From: Mercer Island ePermit Tech
Sent time: 07/06/2021 12:02:00 PM
To: Chris Niederman <Chris@niederman.com>
Subject: RE: 2015-227 Planning Review Comments

I have completed my first round of review of your building permit to install an automatic electric gate at 6800 96th Ave SE, as process under permit number 2105-227. I have the following review comments:

SHEET NUMBER
SK-2

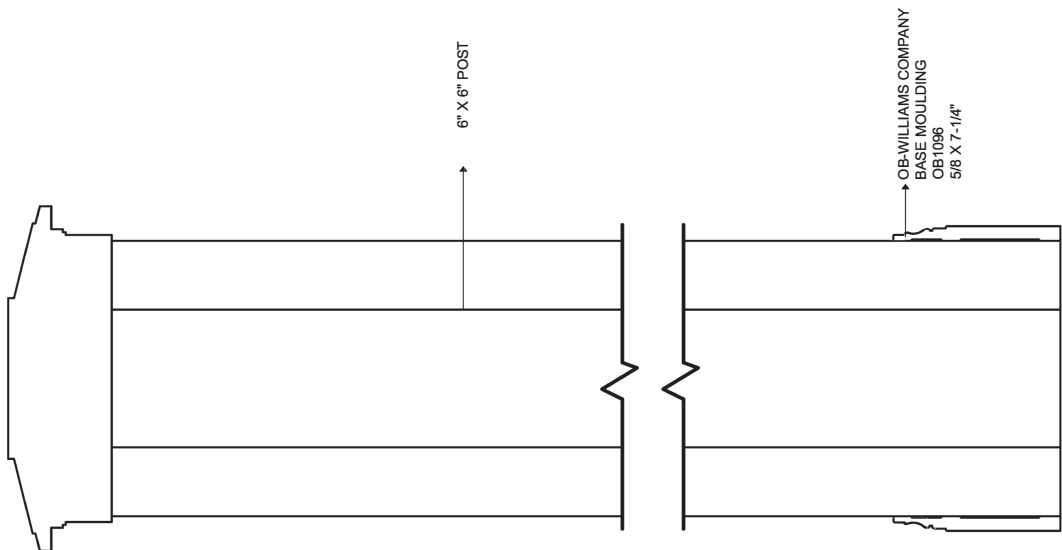
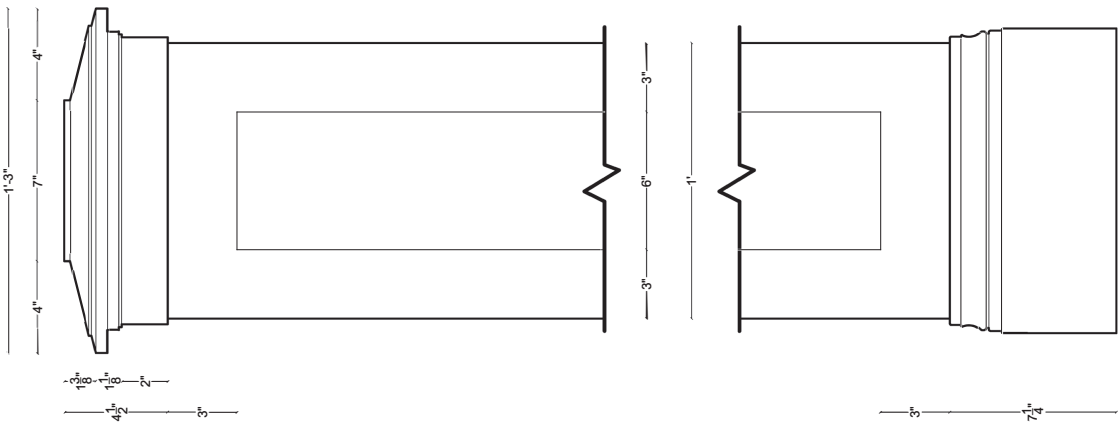
One question....if the top of the posts are at 72 inches then can we still put lights on top of the posts or do the top of the lights also need to be at 72 inches max?

- [MICC 19.02.050\(E\)\(1\)\(a\)\(i\)](#) states that fences and gates are allowed to a maximum height of 72 inches within required side yards. Further, [MICC 19.02.050\(C\)\(1\)](#) states that the height of a fence or gate is measured from the top of the fence or gate, including posts, to the existing or finished grade, whichever is lower, directly below the section of the fence or gate being measured.

The plans show that the posts of the proposed gate and fence are to be 78 inches in height, with elements extending above 78 inches. This exceeds the 72 inch height limit. Please revise the height of the posts so they meet the height limit listed in MICC 19.02.050(E)(1)(a)(i).

Thank you for sending in this updated document. The revised plans show that the proposed fence and gate meet fence height standards, so I have approved the permit for planning. If you have any questions about how the permit is processed from here, I would recommend getting in contact with the Permit Center at epermit.tech@mercergov.org.

MIC 19.02.050(C)(1) states that the height of a fence is measured from the top of the fence, including posts, to the existing grade or finished grade, whichever is lower, directly below the section of the fence being measured. The lights are part of the posts, so they would also need to meet the 72-inch height limit for the fence.
